## OFFICIAL NOTICE OF DECISION

CITY OF ALBUQUERQUE  
PLANNING DEPARTMENT  
DEVELOPMENT REVIEW BOARD

**5. Project # 1003523**  
05DRB-01369 Major-Preliminary Plat Approval  
05DRB-01368 Major-SiteDev Plan Subd  
05DRB-01370 Minor-Temp Defer SDWK

RIO GRANDE ENGINEERING agent(s) for GHP, LLC request(s) the above action(s) for LOT 30, 31, 32 and 33, LANDS OF ATRISCO GRANT, UNIT 3, (to be known as **PRIMA ENTRADA SUBDIVISION**) zoned SU-2 FOR R-LT, located on 98<sup>TH</sup> ST NW, between ENDEE RD NW and I-25 NW containing approximately 17 acre(s). [REF:04EPC-01003, 04EPC-01352, 04EPC-01489] [*Deferred from 9/28/05 & 11/2/05 & 11/9/05 & 11/23/05*](J-8)

**PLAT OF  
PRIMA ENTRADA  
TOWN OF ATRISCO GRANT  
PROJ. SEC. 16 AND 17, T.10N., R.2E., N.M.P.M.  
ALBUQUERQUE, NEW MEXICO  
JULY 2005**

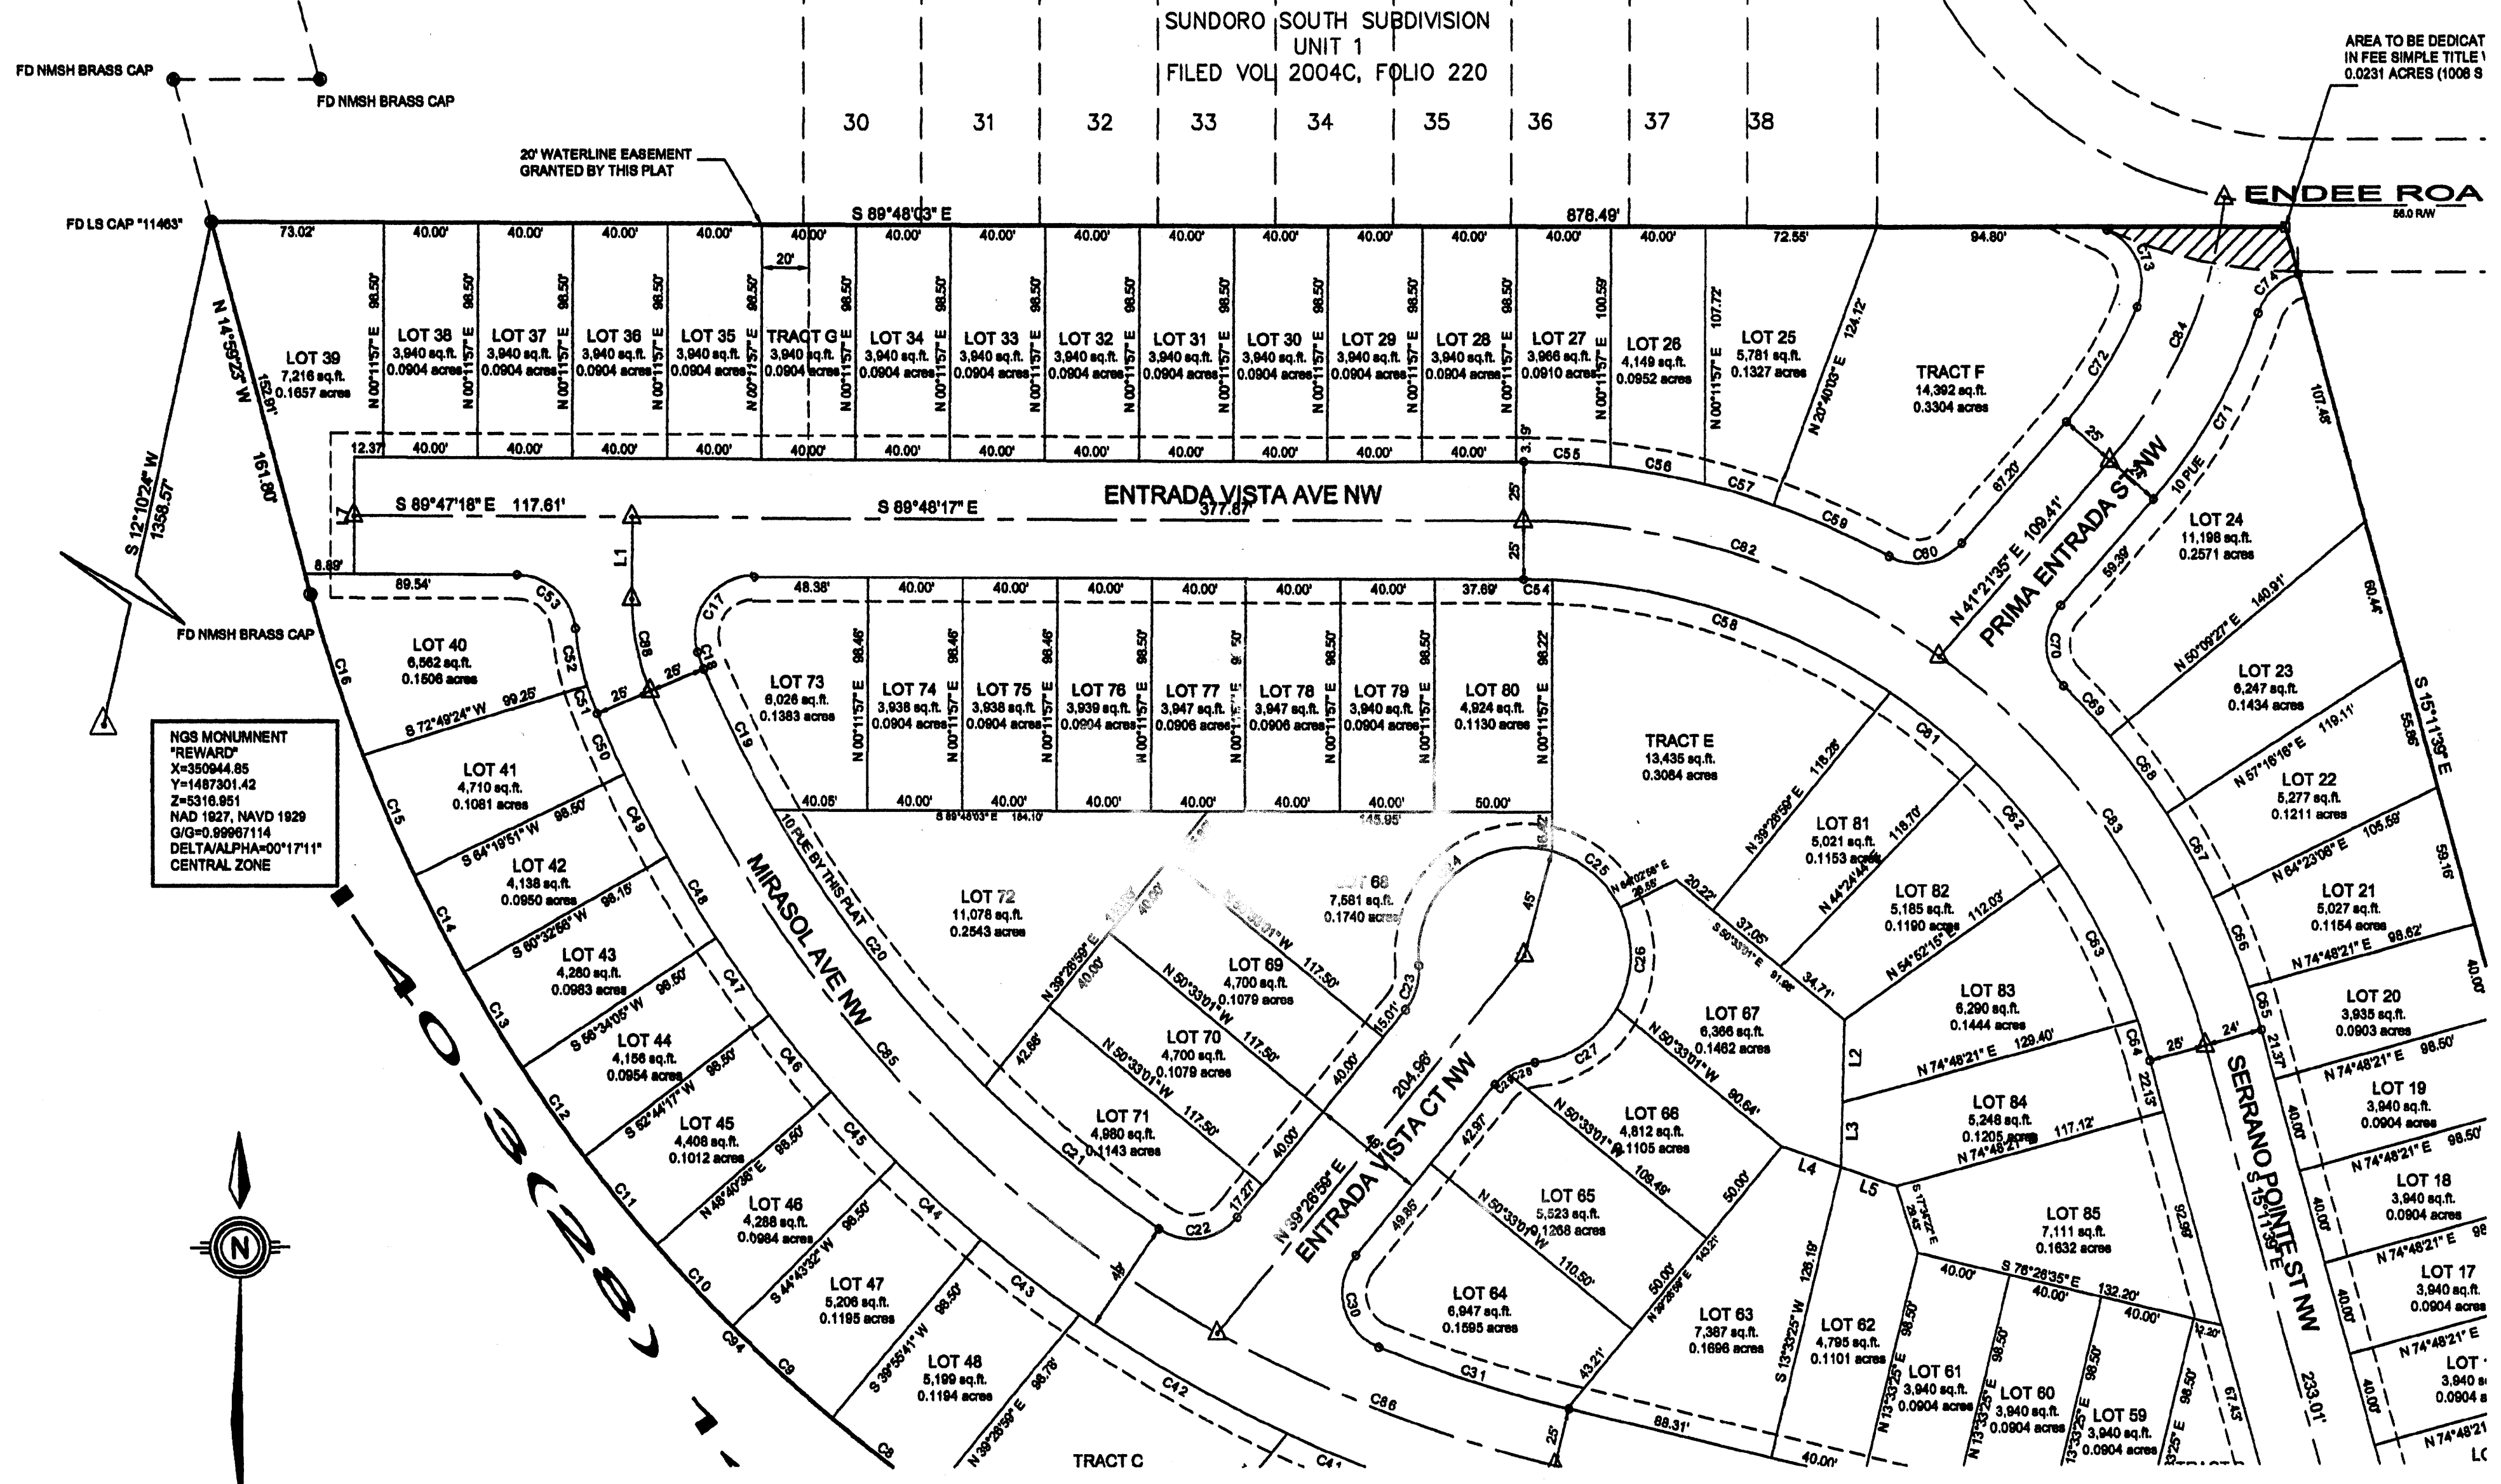
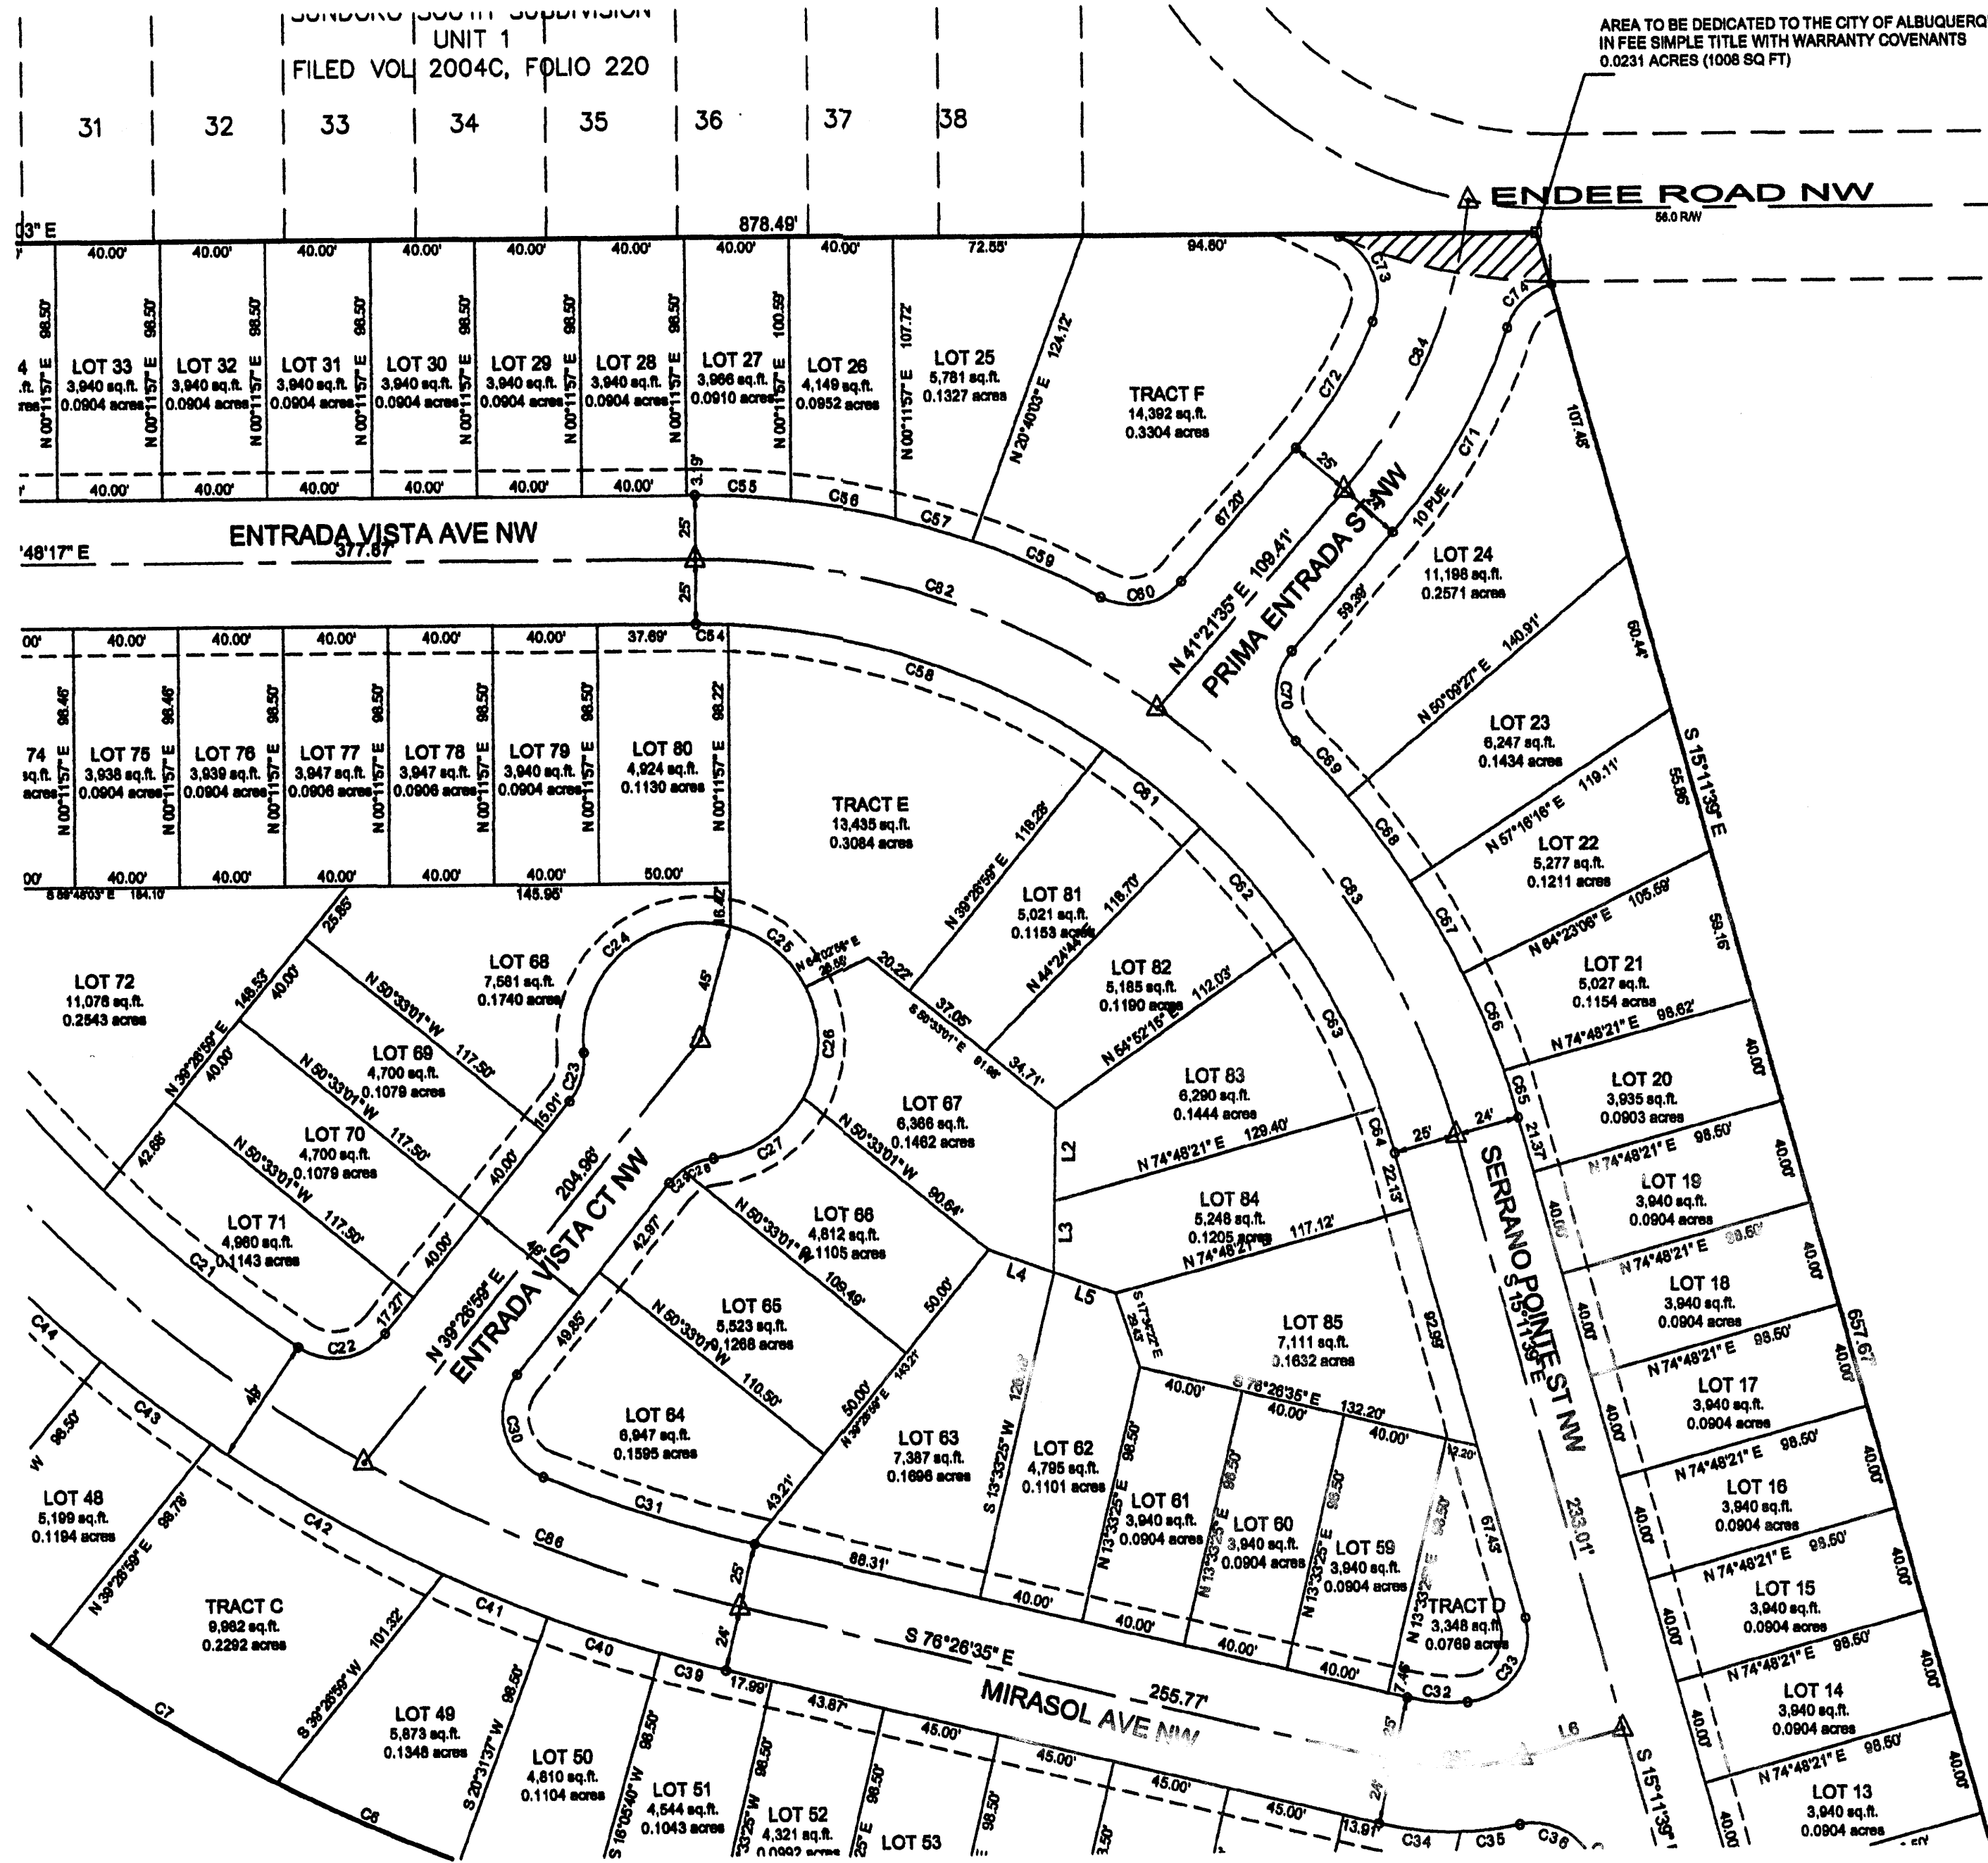
P-1 lot designations.

Entrada Vista Court shall become a private access easement. Maintenance and Beneficiary Statement shall be placed on the plat.

The zoning designation shall be on the final plat.
